Response to Planning Application

From: Arun District Council Greenspace

Application ref: Y/123/21/PL

Description: Variation of condition imposed under Y/82/20/RES - following outline consent Y/80/16/

Play Area (LAP 2) - Scale 1:100@A1

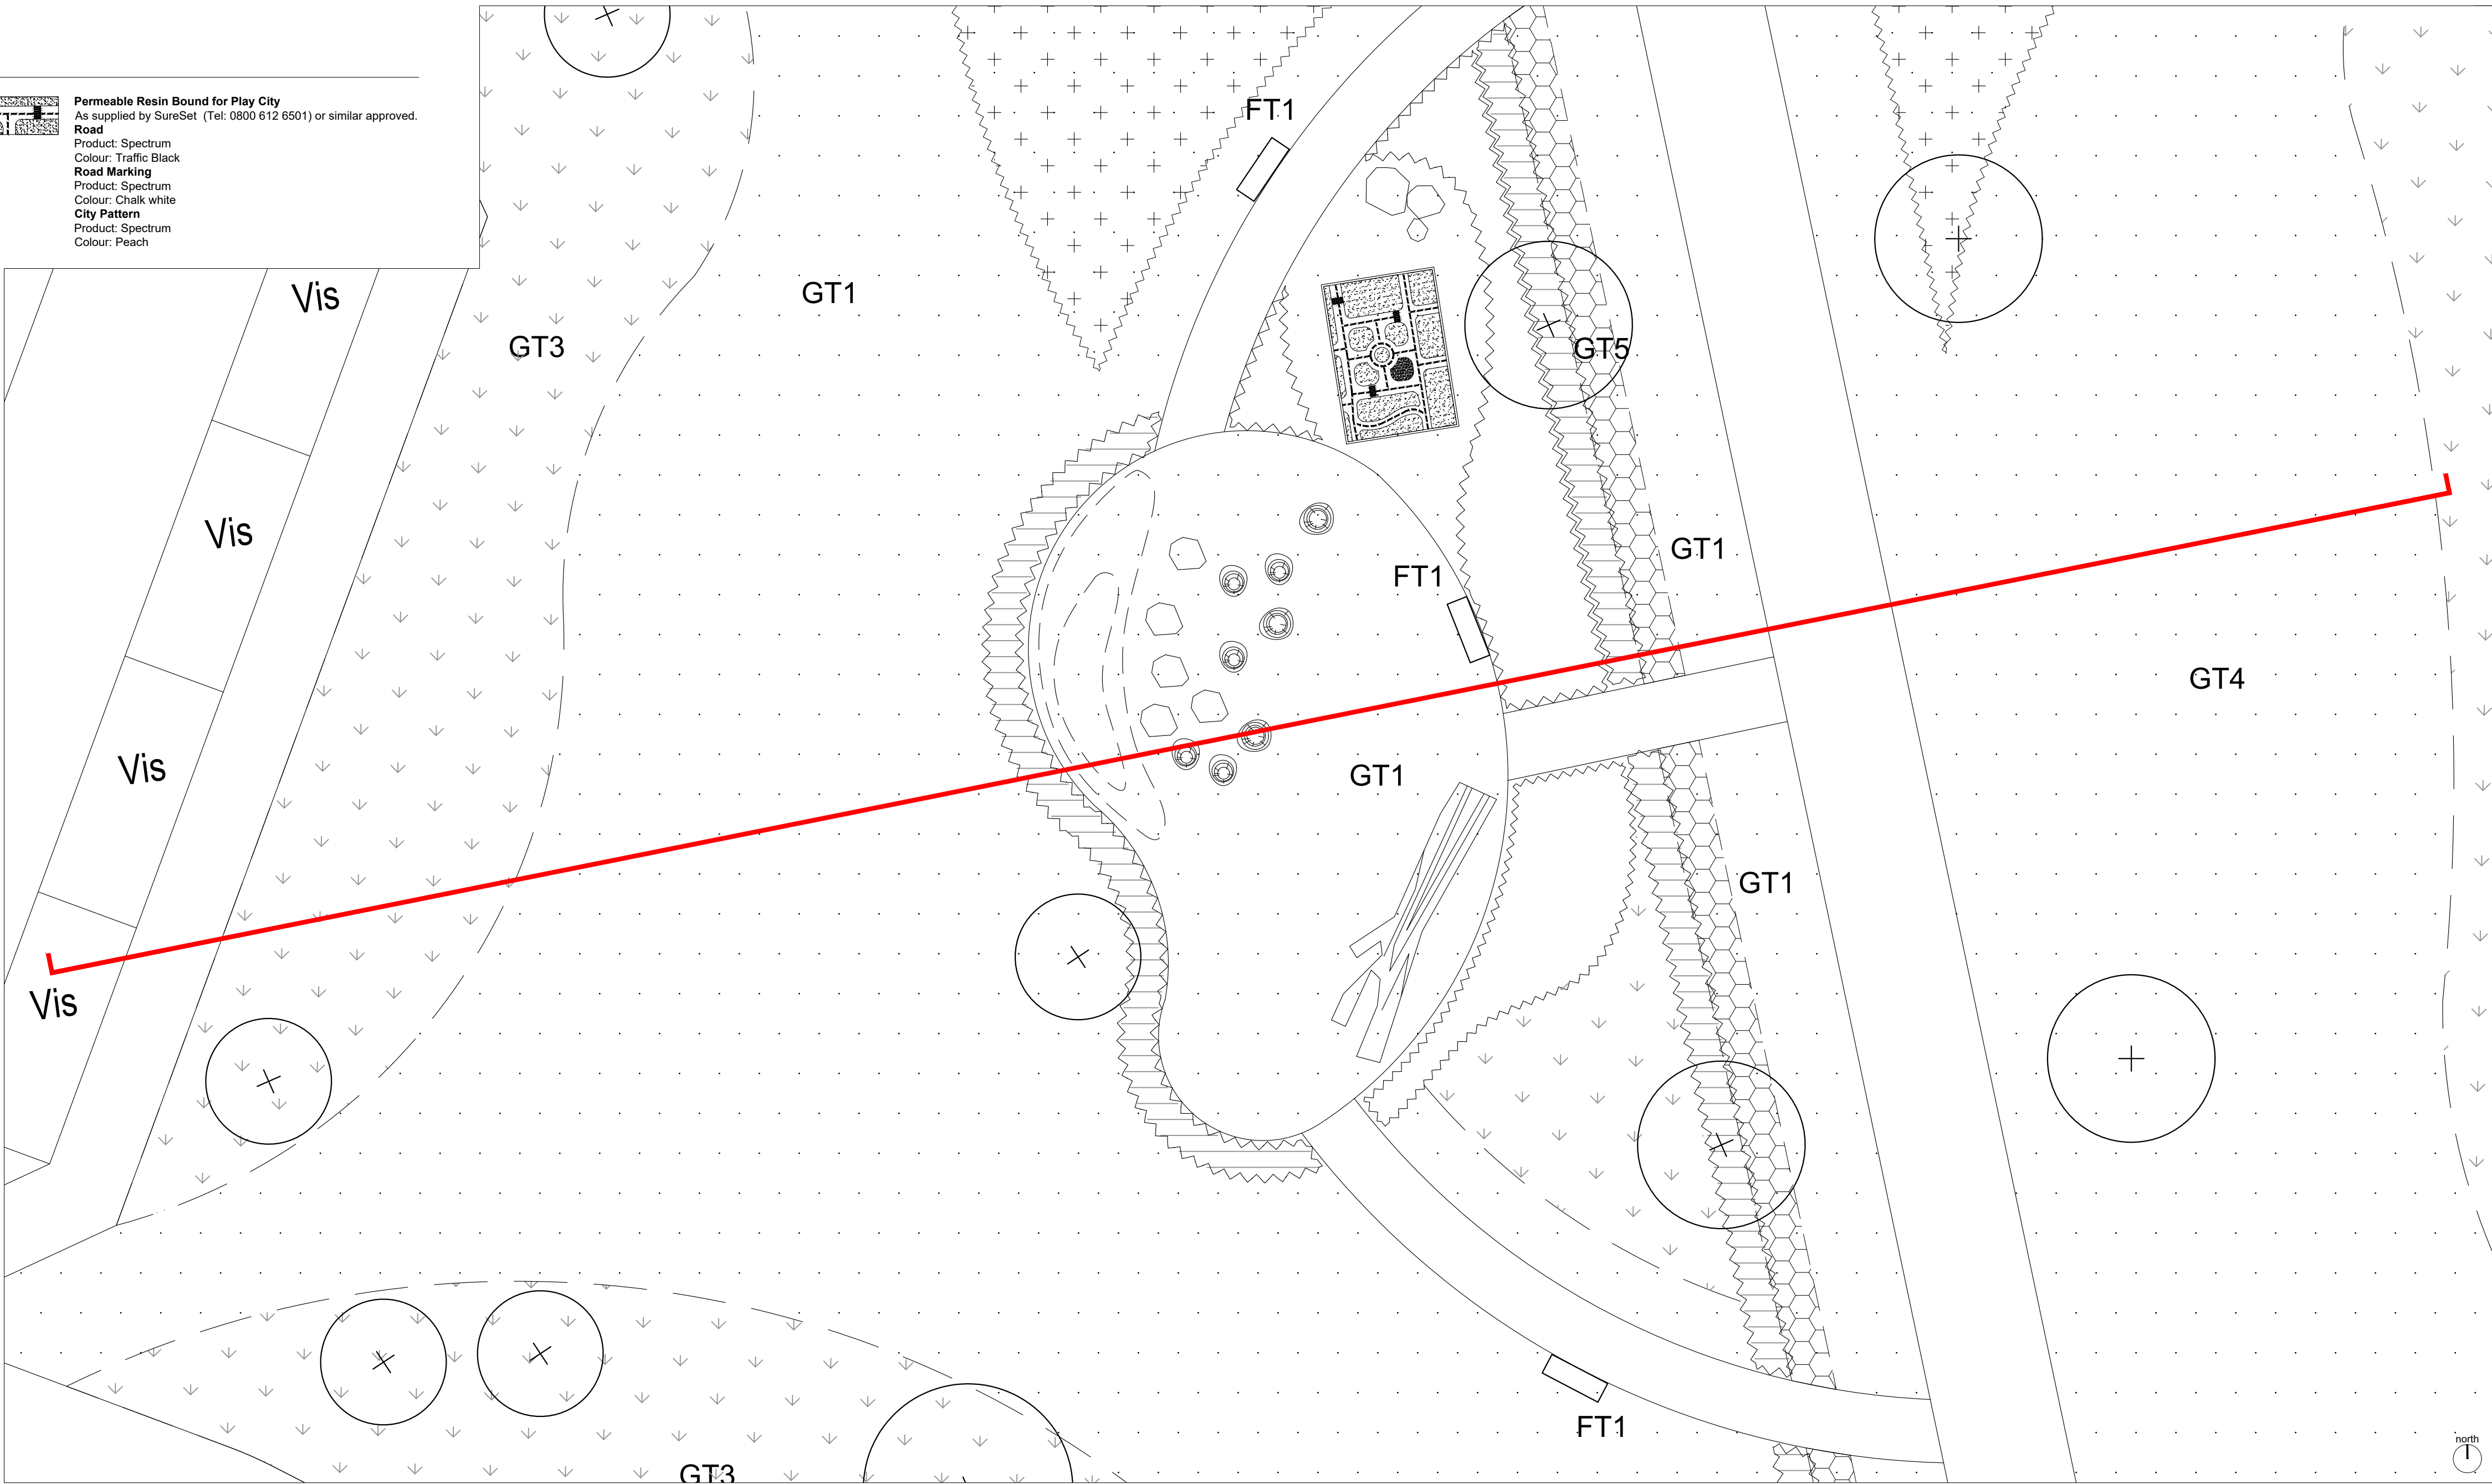
- Pathway surfacing is also not detailed to the LEAP and LAP play areas, this needs to be shown and again due to high use needs to be Tarmac in finish. Pathways shown as grass mown paths would not be considered good choice within the POS areas as they invariably do not become mown paths within the maintenance undertaken. Any formal pathways need to be suitably surfaced and in the POS periphery area of grass, permeable pathways ie should be considered in favour of mown grass paths.

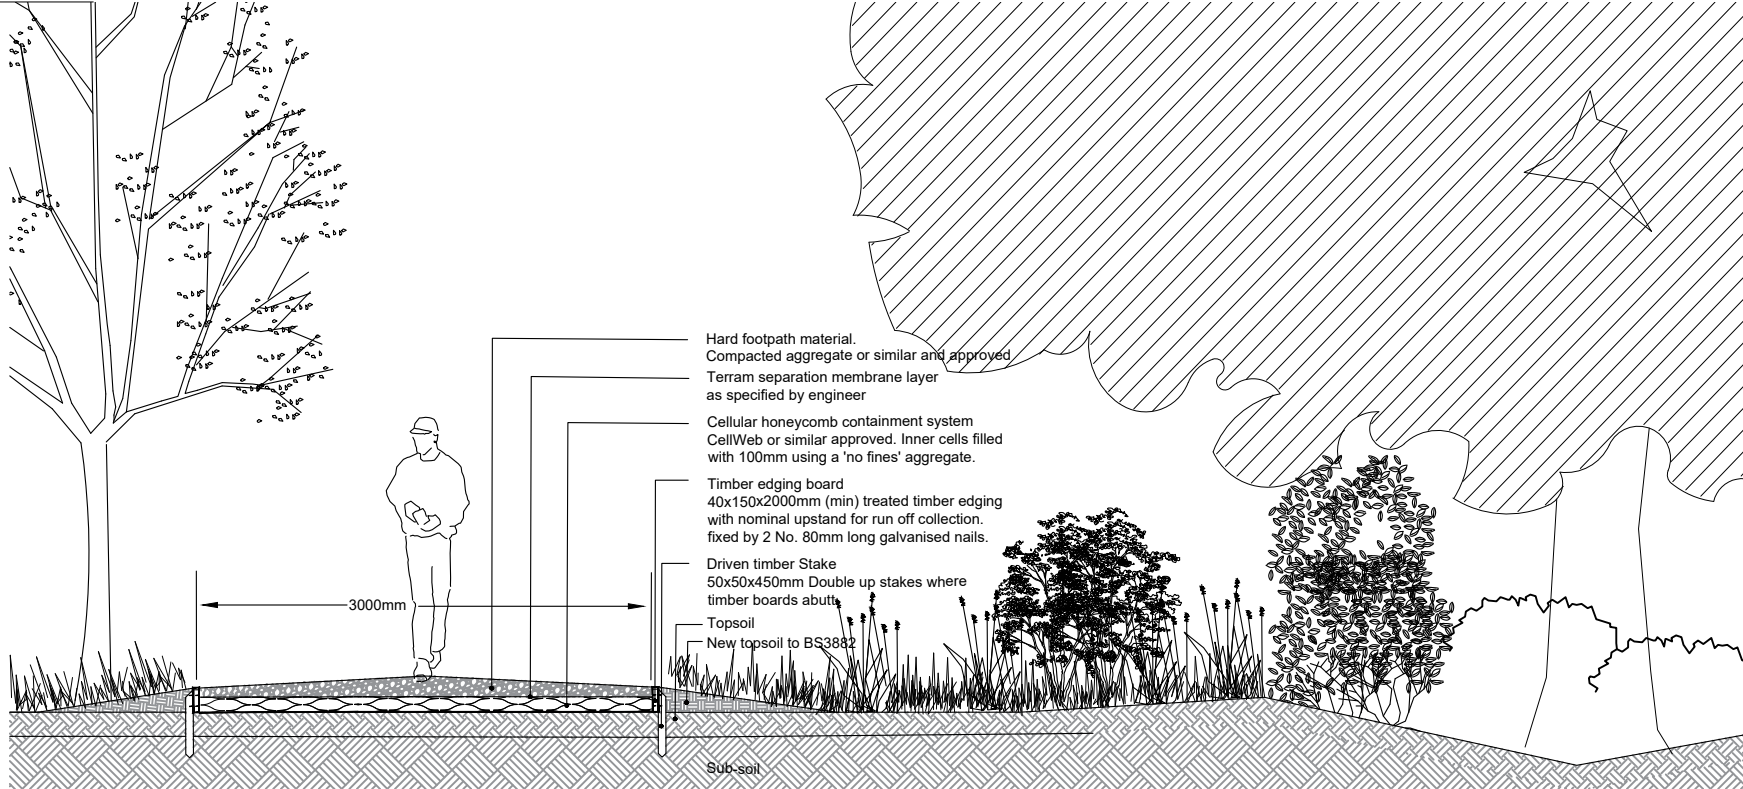
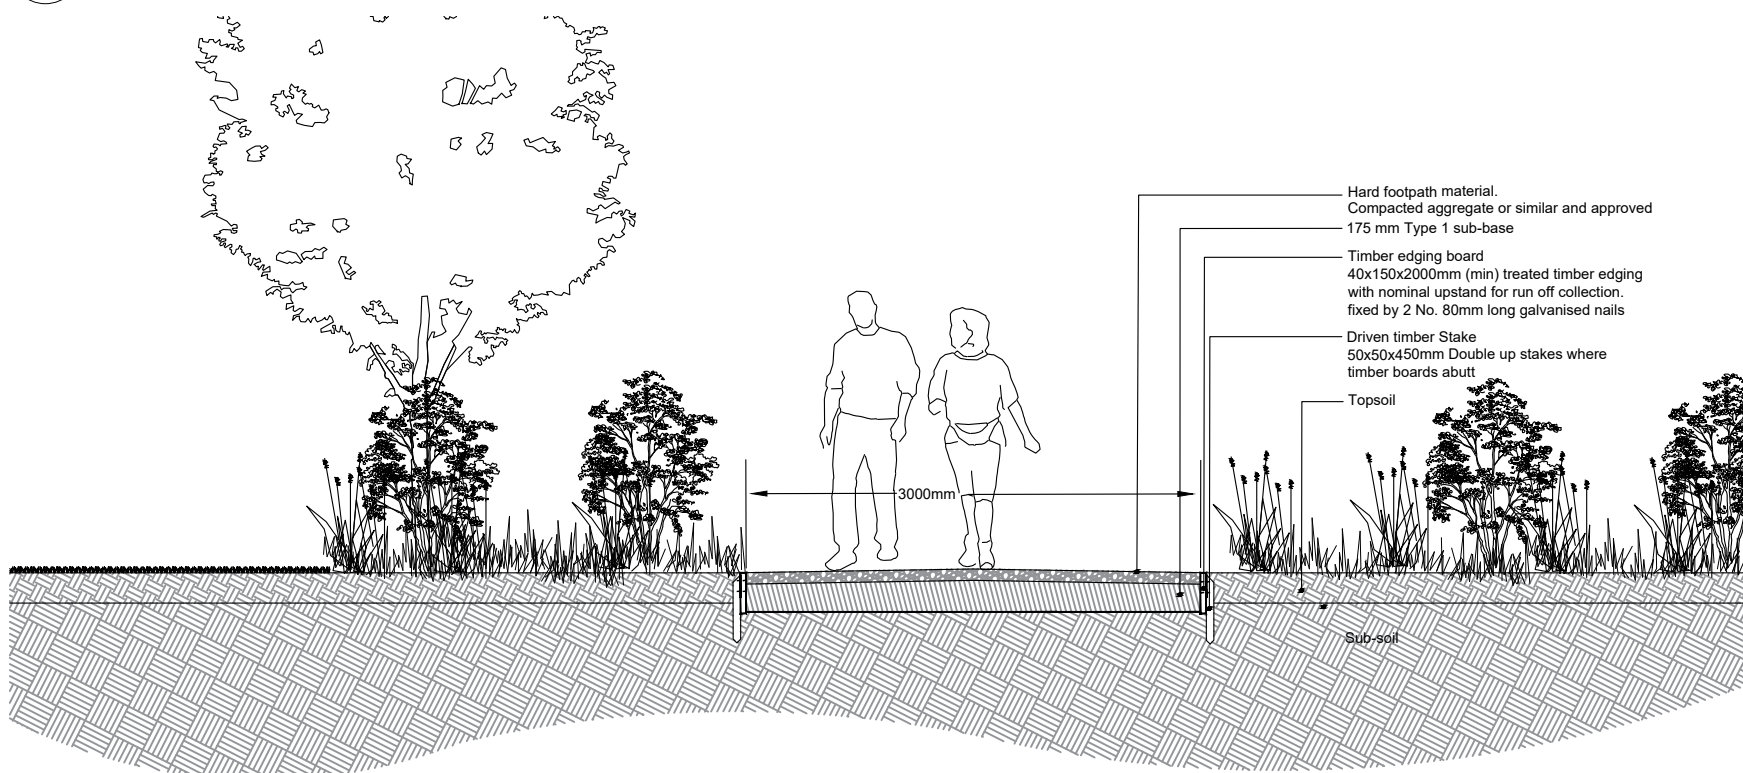
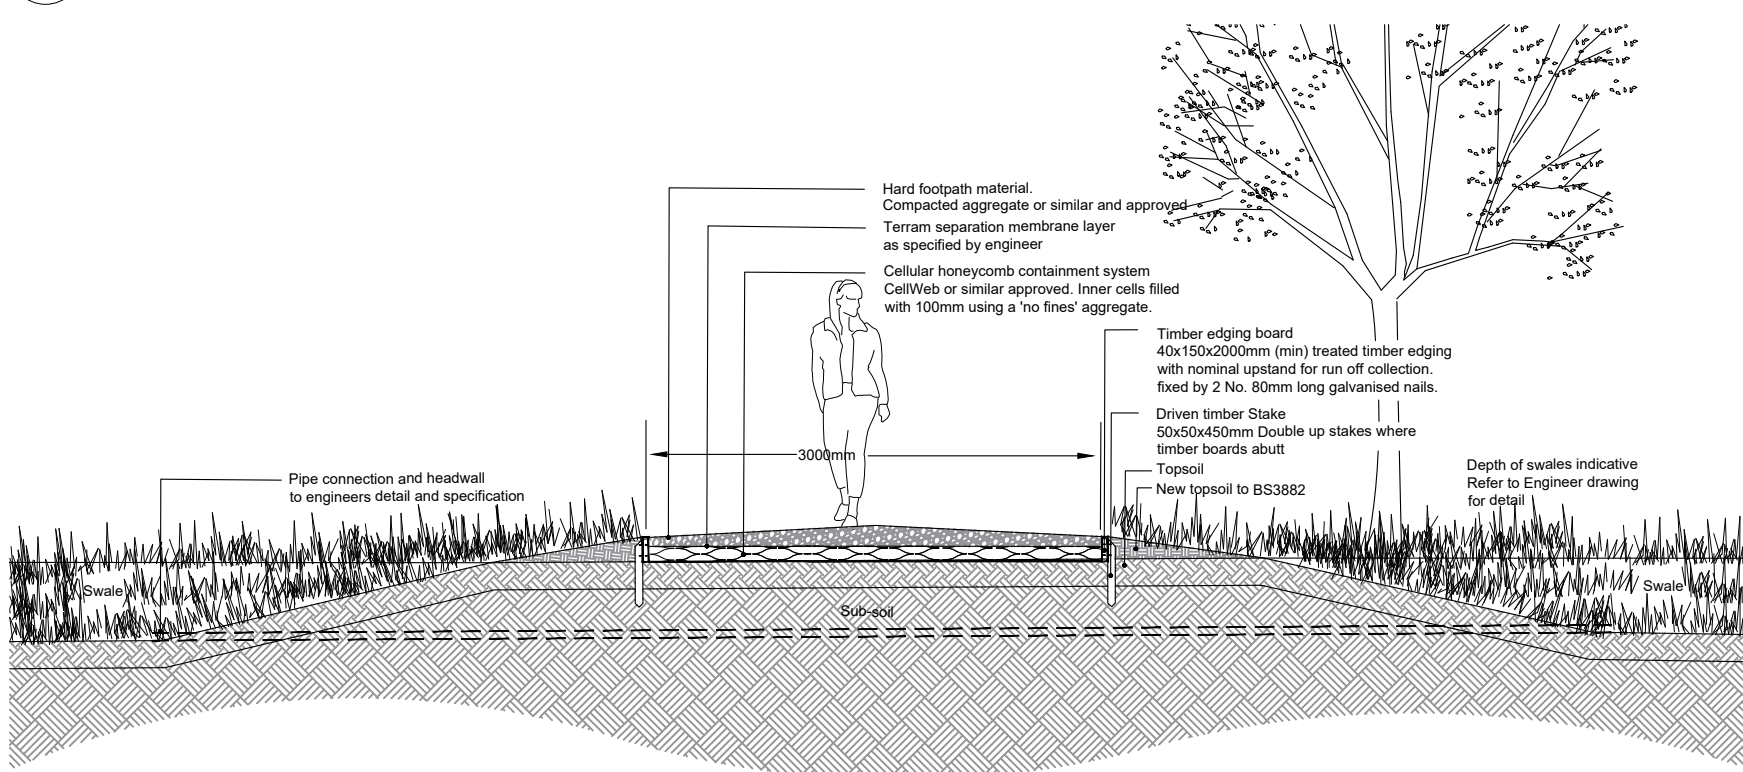
- Bridleway to the eastern edge – This is detailed as Fittleworth self-binding gravel. The surfacing of the bridleway needs to be suitable for use and fit for purpose and allow usage by pedestrian and wheeled users also. The bridleway construction and surfacing proposed needs to allow for a robust construction with suitable materials and detail re construction depth and material choice submitted for approval. **Cross section bridleway construction to be provided.**
